Our Ref: FG/135/13/

Application for Planning Permission for Works or Extension to a Dwelling

Development Modernise front entrance with in-fill extension to front. Rear extension of 1.5 depth with part glazed and part mono pitched roof.

Location 16 South Drive Ferring

EXISTING ELEVATIONS 1:100

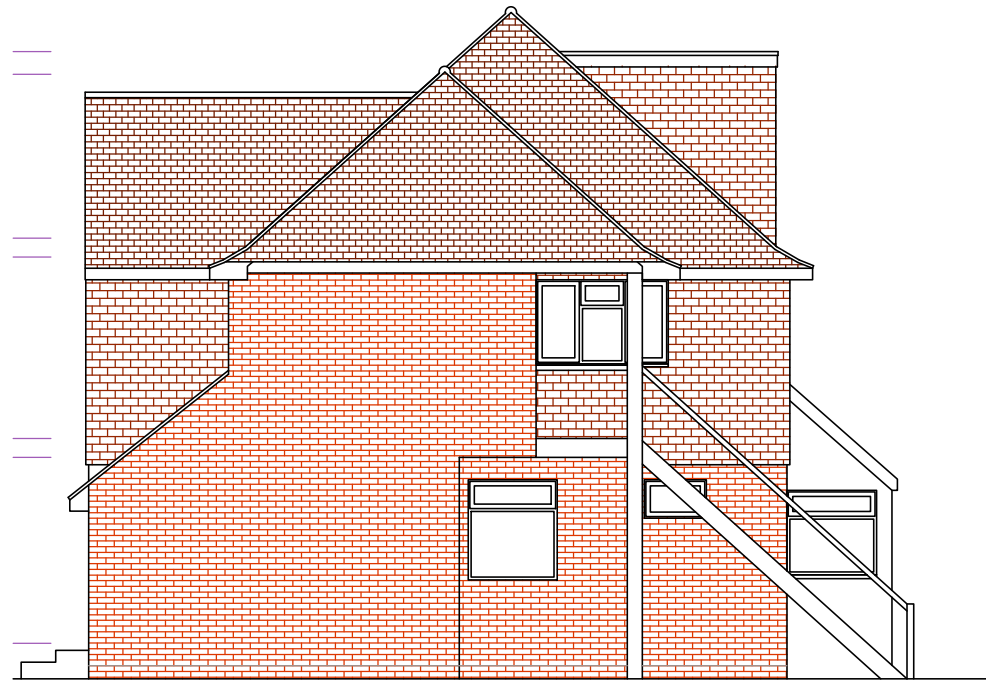
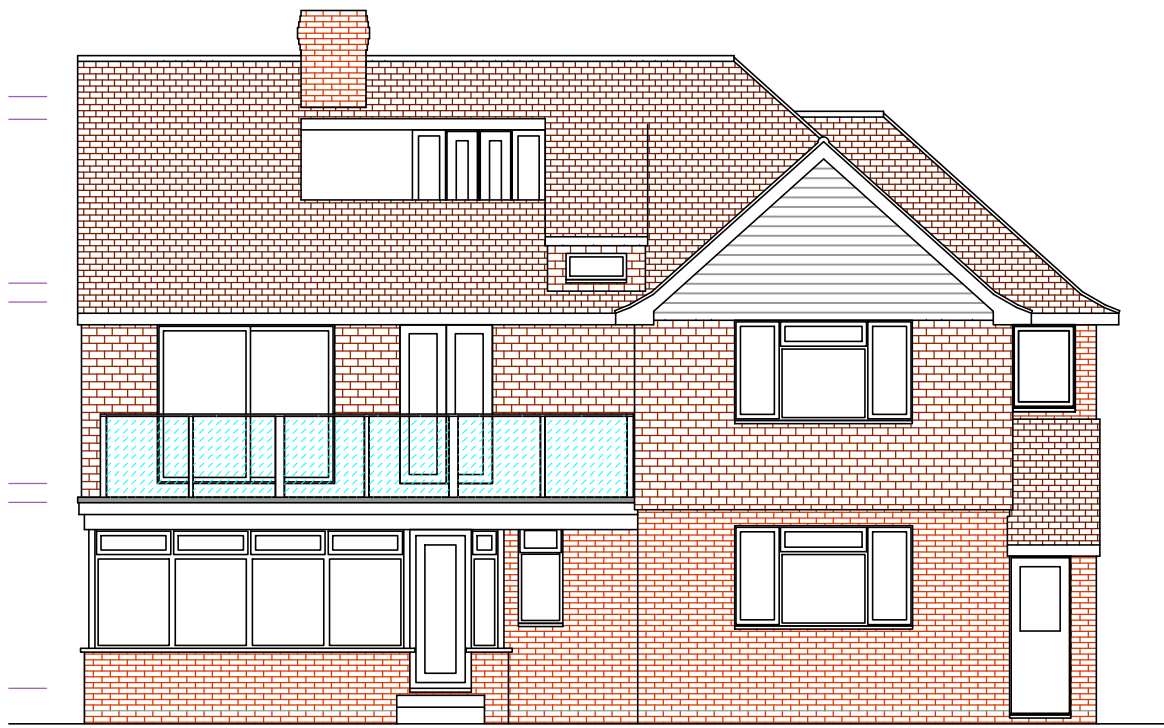
Please submit 1 electronic or 3 paper copies of revised existing and proposed elevations at a scale of 1:50 or 1:100, the East elevations do not accord with the floor plans, there appears to be a window from Bedroom B2 missing from the elevation drawing. Further details can be found in the National Validation Requirements.
